Reference	CD/22/2211
Description	<b>Discharge of condition 5 (Ecology-precautionary method of works) of planning permission PF/22/054 (Removal of existing barn and erection of detached domestic outbuilding to be used as a gym / home office), ,</b>
Site Address	Strange Farm, Grange Road, Felmingham, North Walsham, Norfolk, NR28 0LT,
Planning Officer	Alice Walker

Name	Ben Jervis (Senior Landscape Officer)
Service Area	Landscape (NNDC)
Reason for consultation

Reply Date	22/09/2022					
	Advice	X	No Comment*		Support	Object

Figure 1: demolition stages for the barn

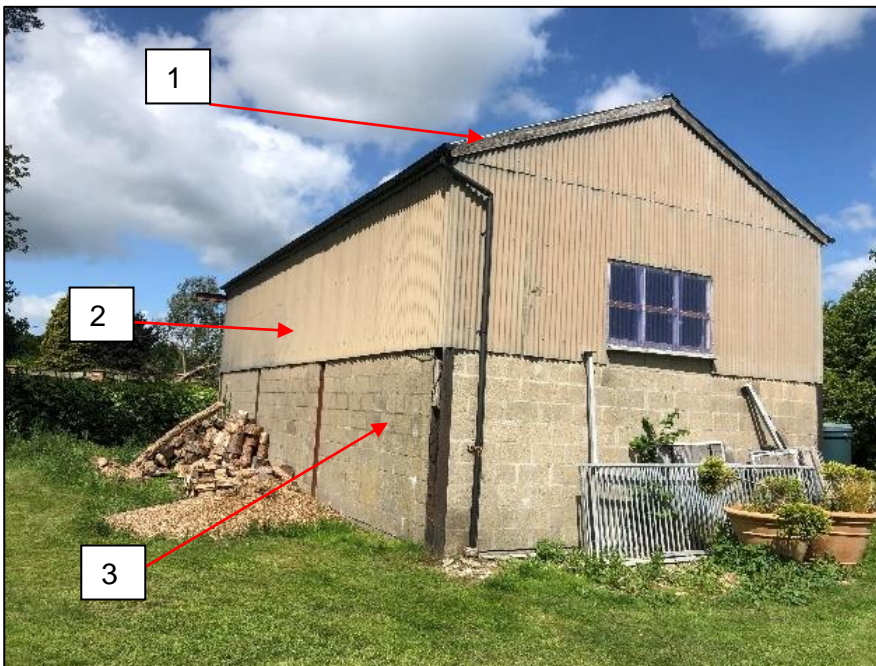
The Landscape Section does not currently consider the document sufficient to discharge Condition 5 due to a lack of information regarding a timetable for implementation, as required by item d) of the condition. Consideration must be given to sensitive timing of works, i.e. demolition works must commence outside of the hibernation period which is generally mid-November to mid-March dependent upon daytime temperatures.

Additionally, it is worth noting that some features, such as breezeblocks, may require inspection with the use of an endoscope. Where this is the case, the ecologist must be suitably licensed to carry out such activities, i.e. hold at least a Level 2 Class Survey Licence, with the view that roosting bats may be present.

Drawings courtesy of Scott Timber Buildings, 2022

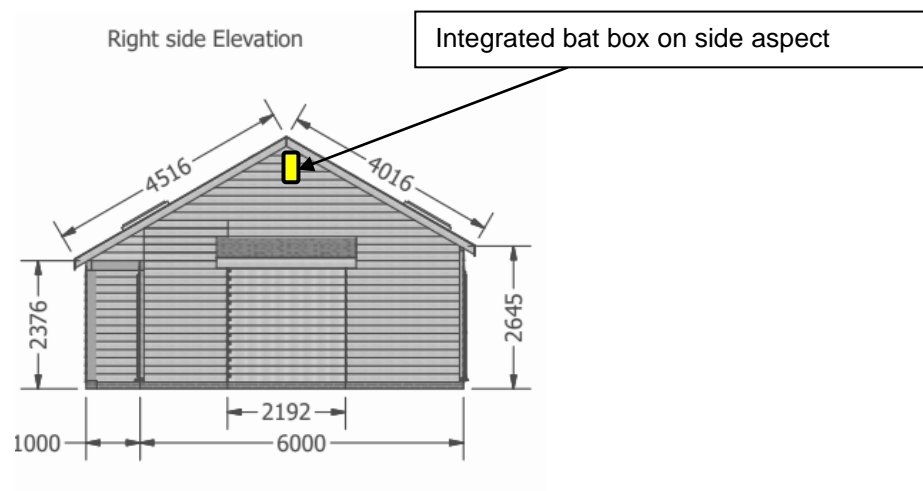
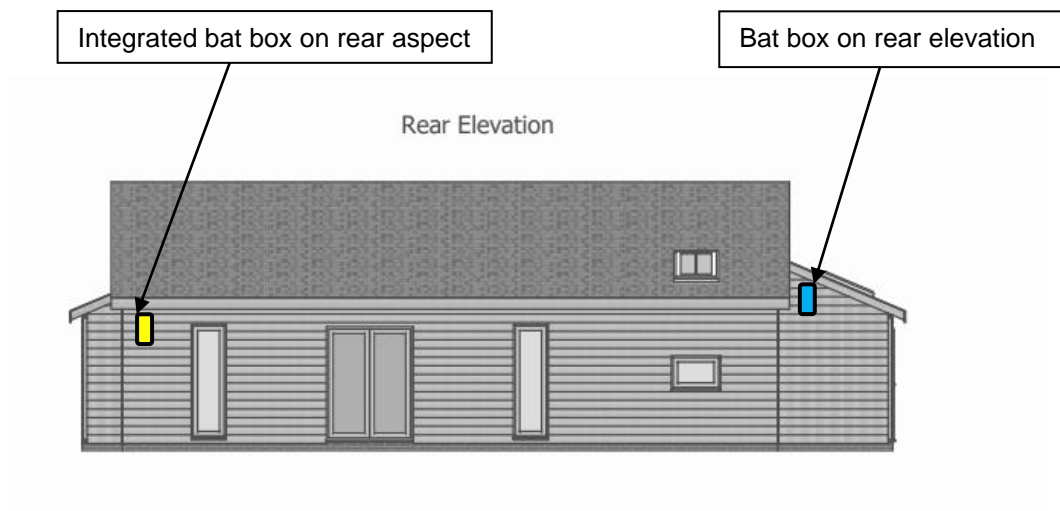
Installation of mitigation and enhancement features may also require supervision by a suitably qualified ecologist to ensure correct installation.
